As with the public consultation, Gate Burton Energy Park Ltd has applied the principle of a Rochdale Envelope as an excuse not to provide detailed evidence on their application. Instead of applying a "cautious and worst case approach" they have not provided any detail on major aspects of their scheme in the draft Development Consent Order.

PROJECT
Gate Burton Energy Park

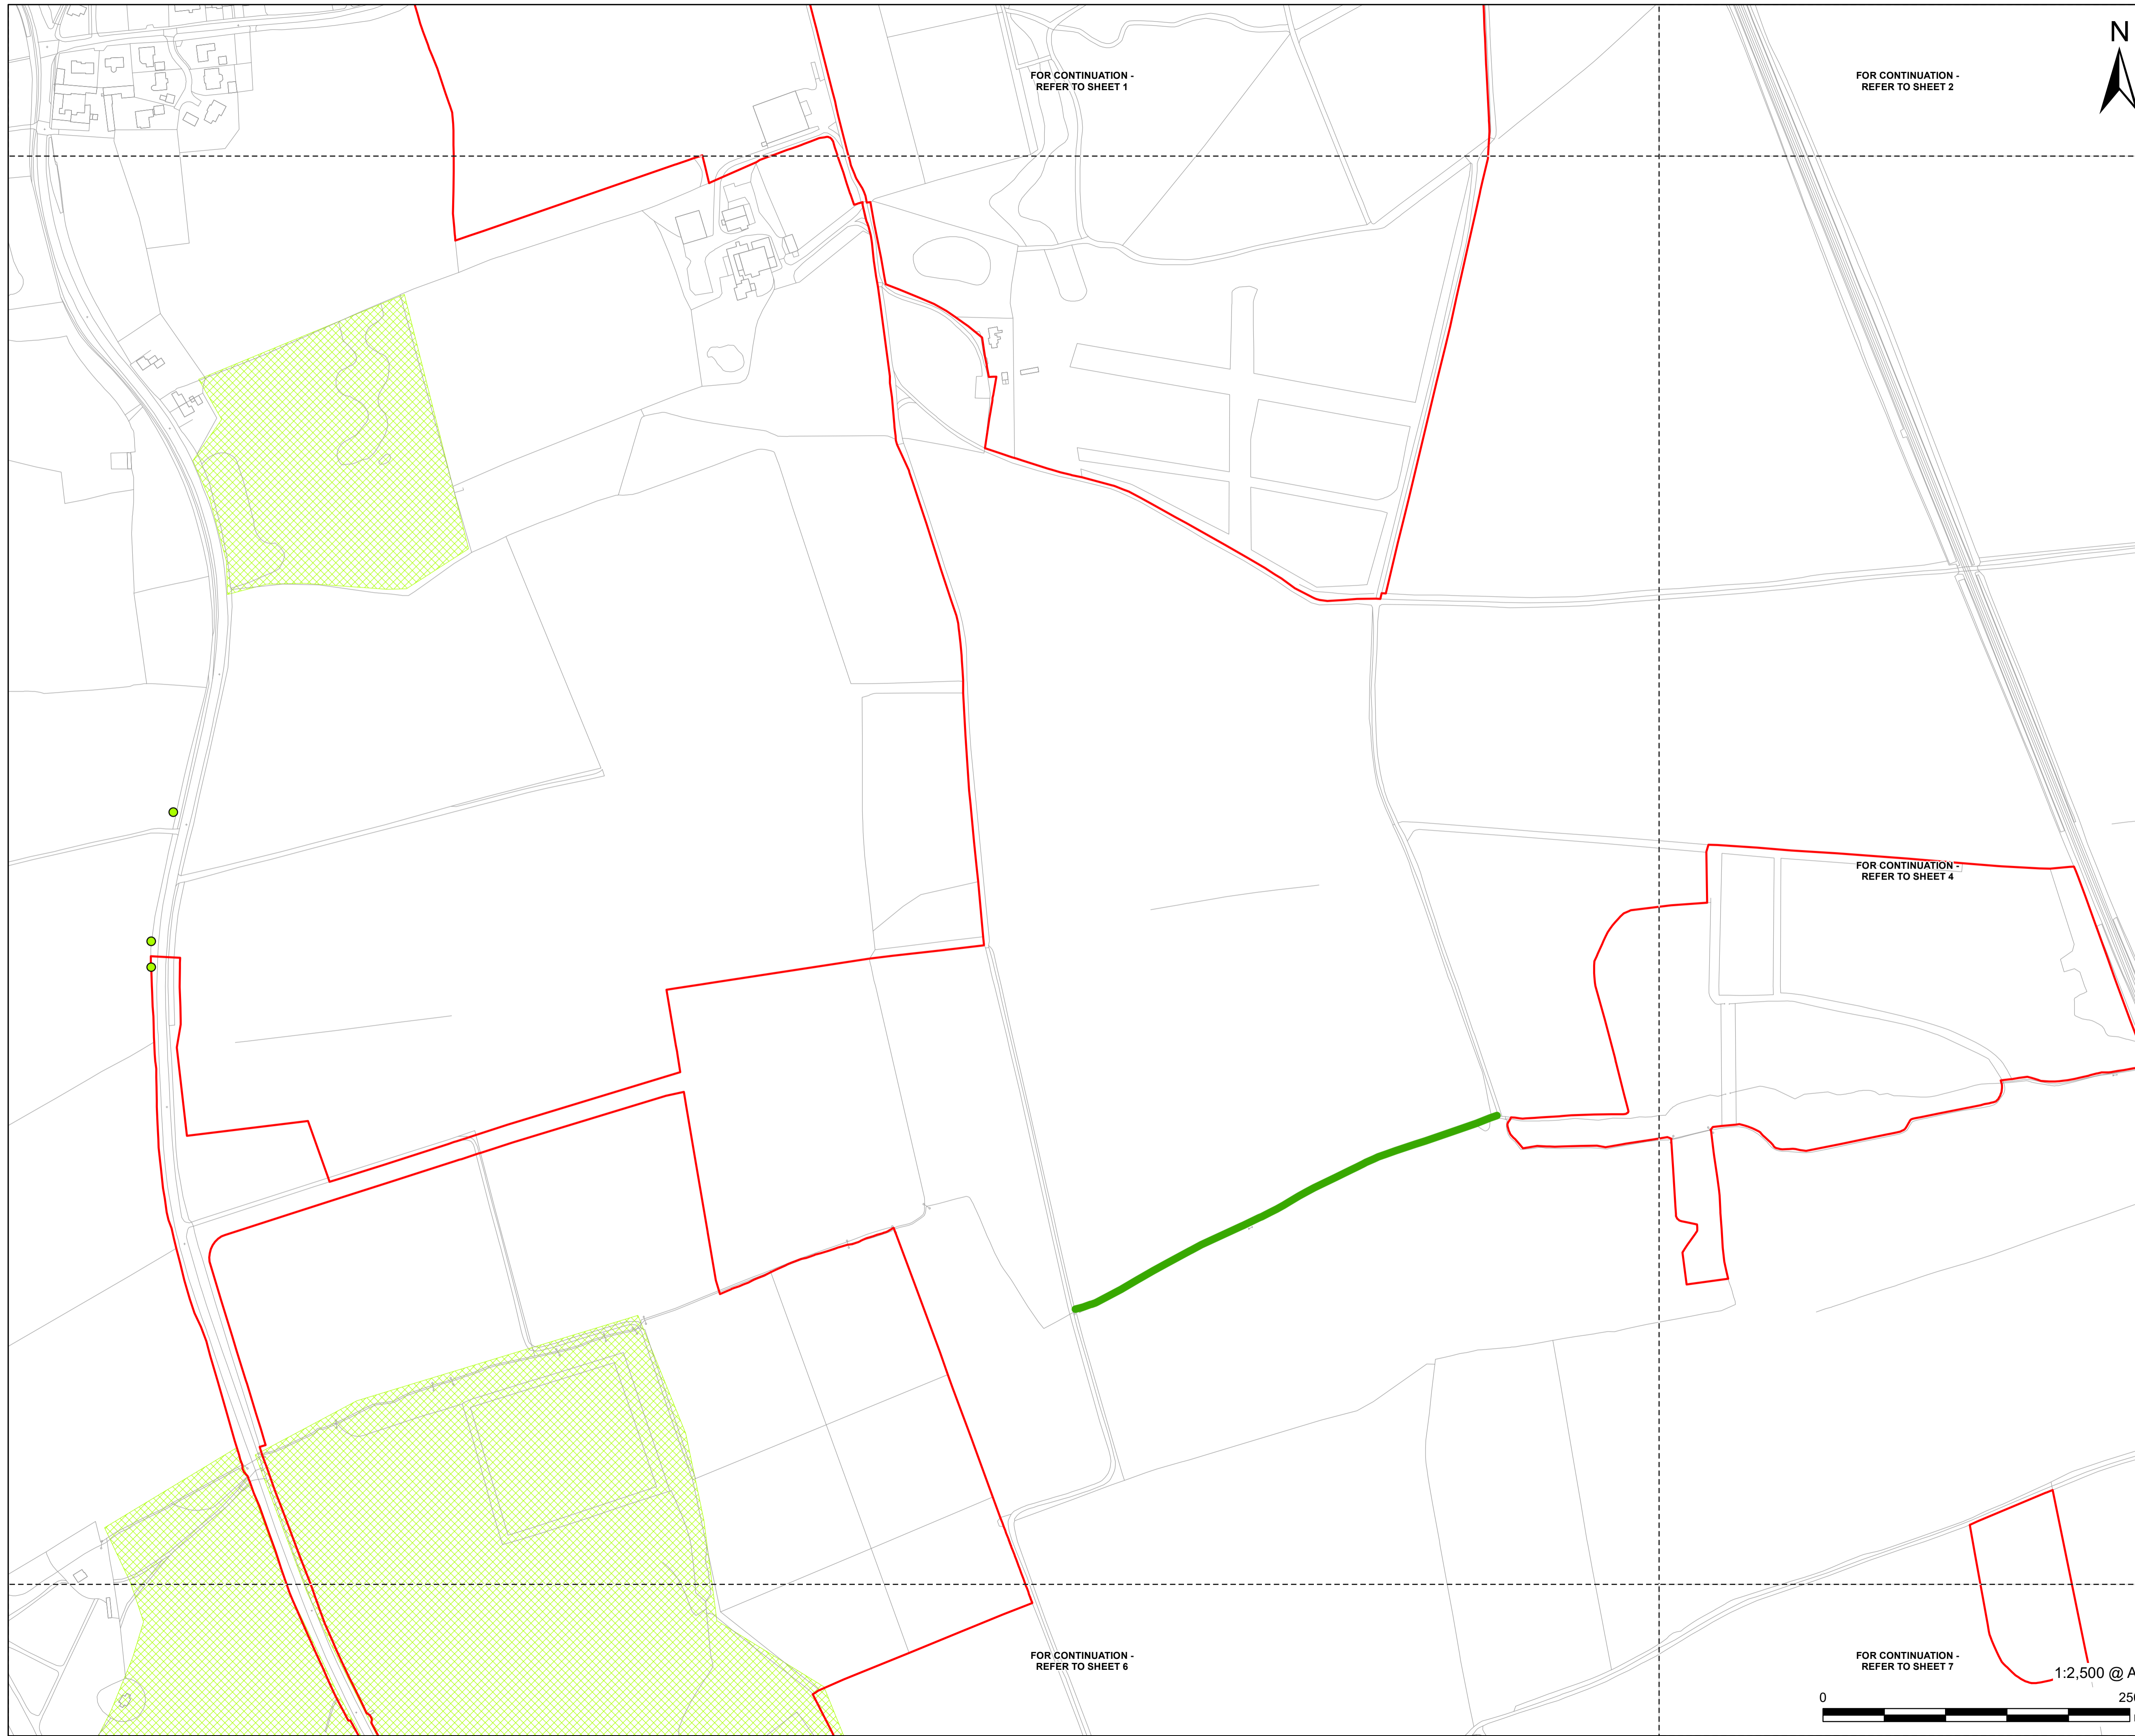
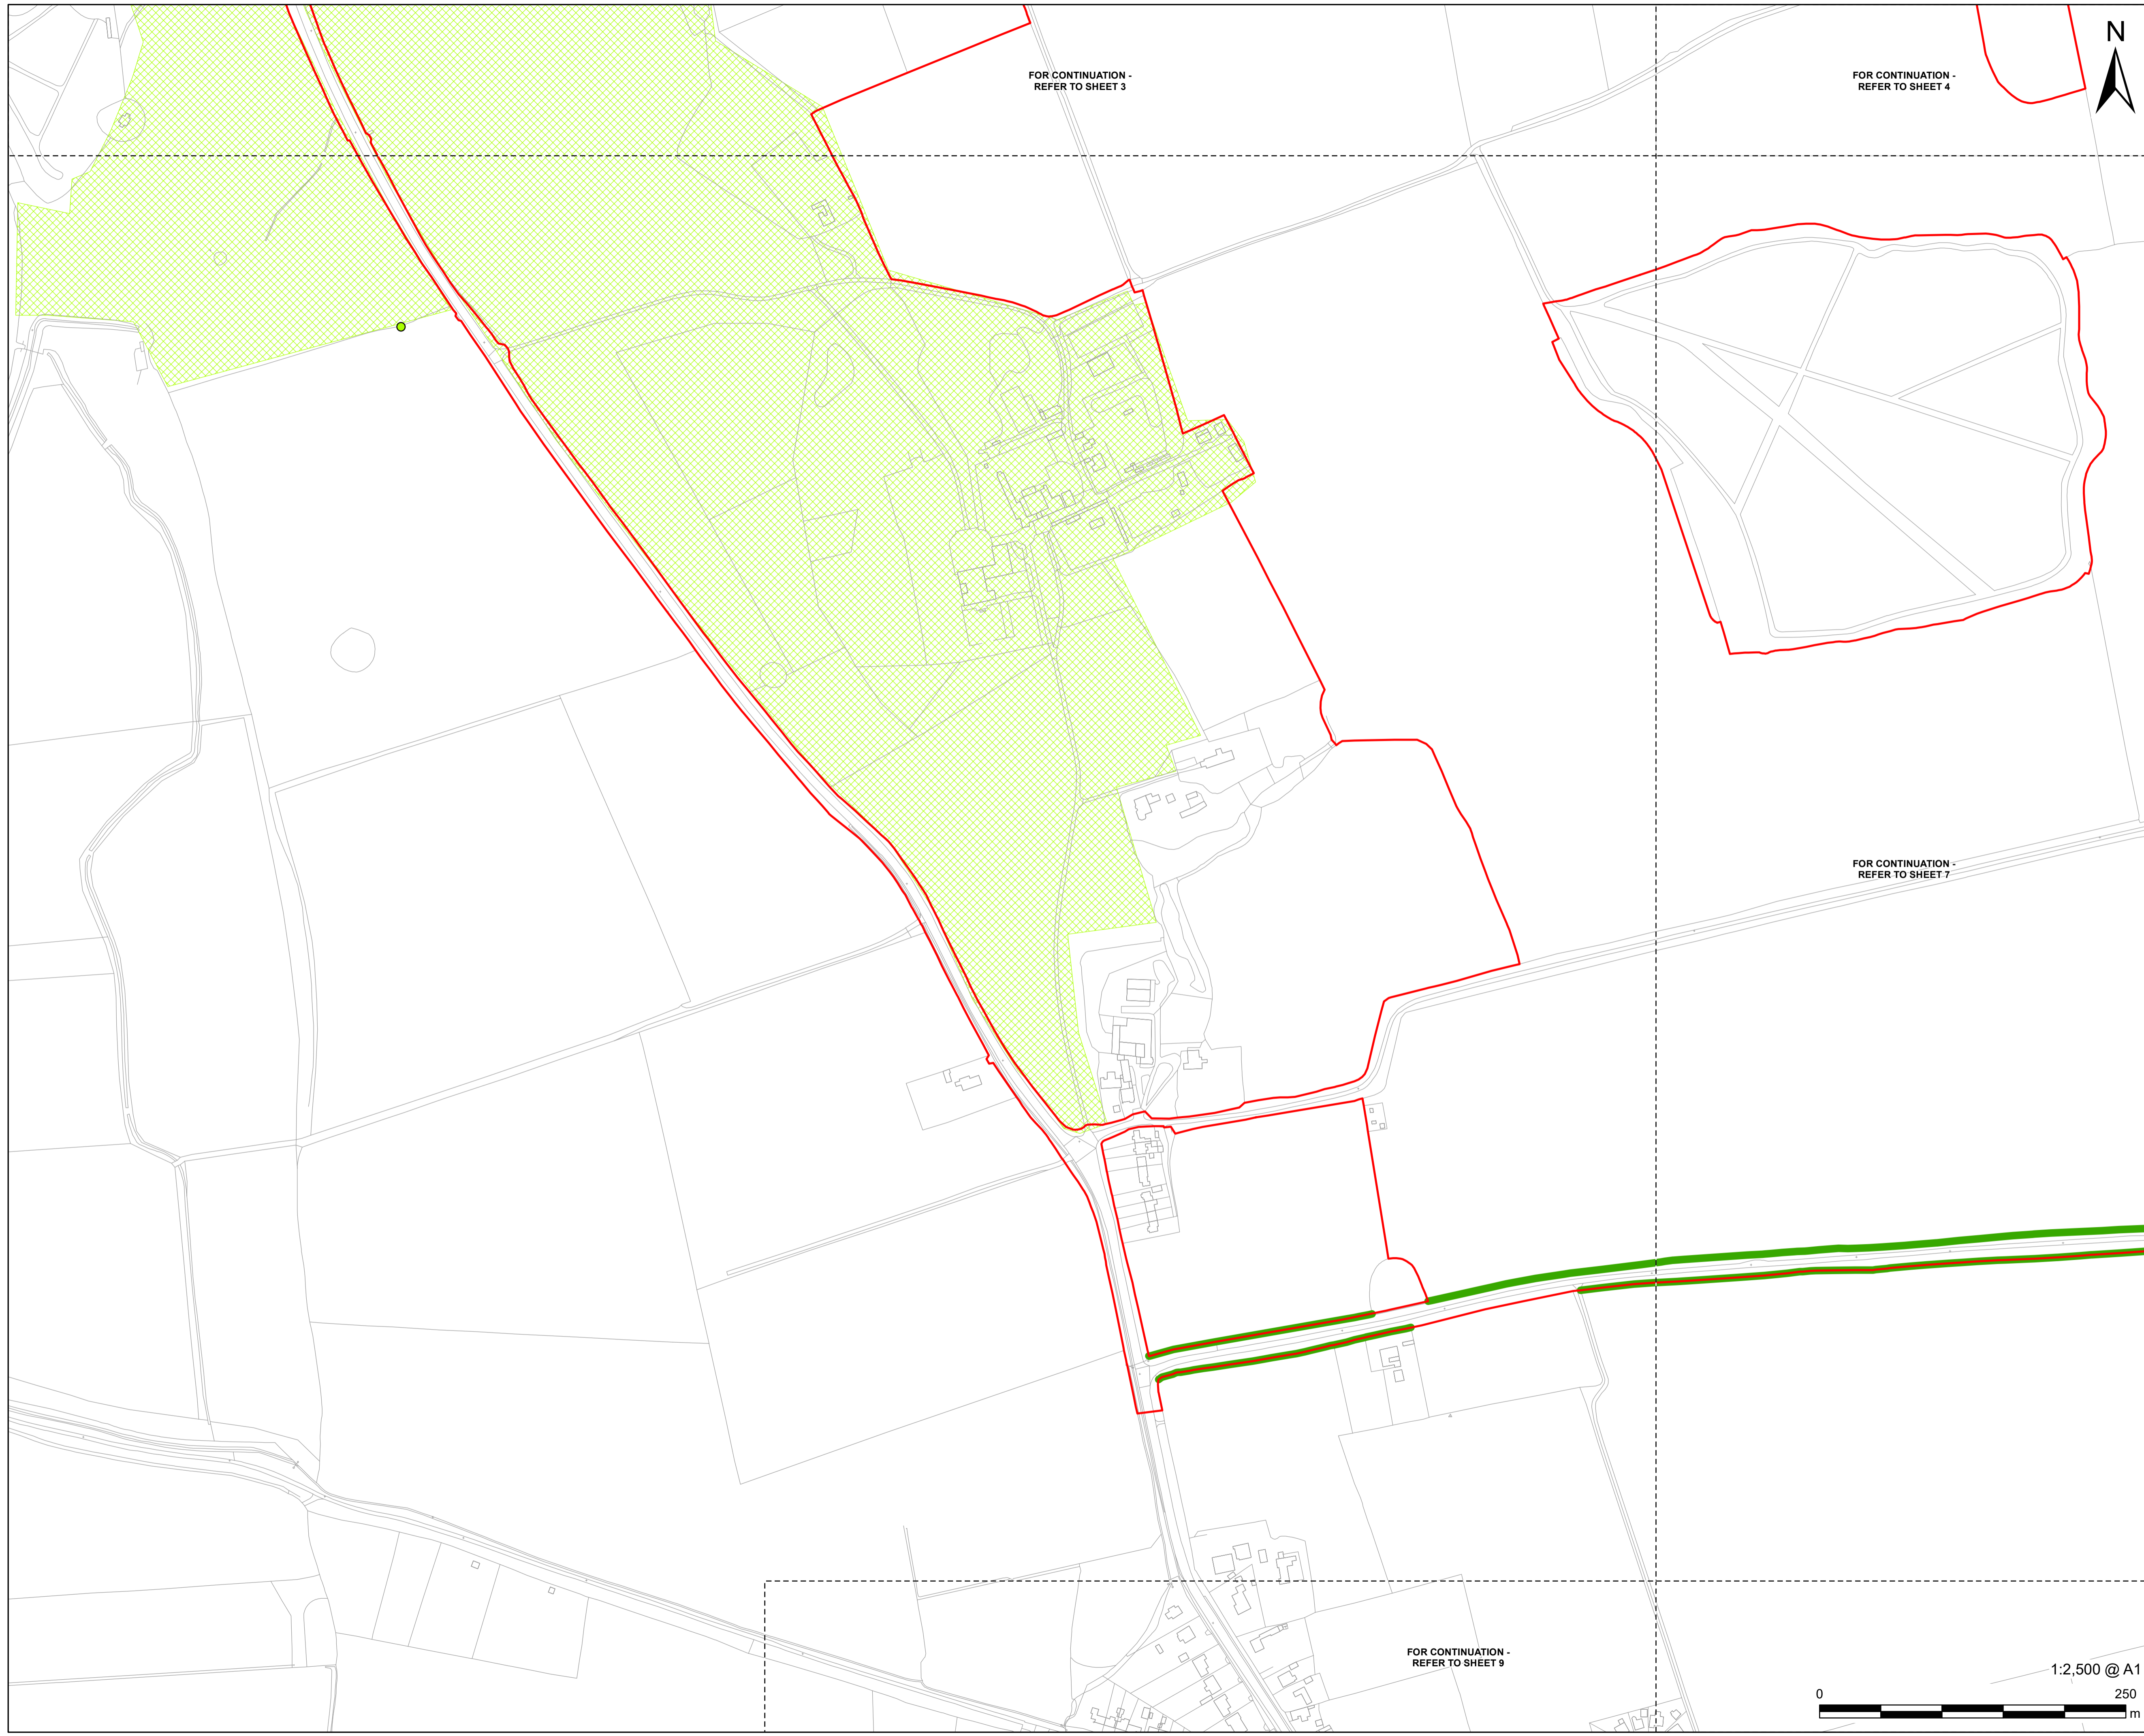
- No information on the scale of hedgerow and tree removal is provided. The adjacent Cottam dDCO provides full disclosure of the circa 55km of hedgerows to be destroyed.
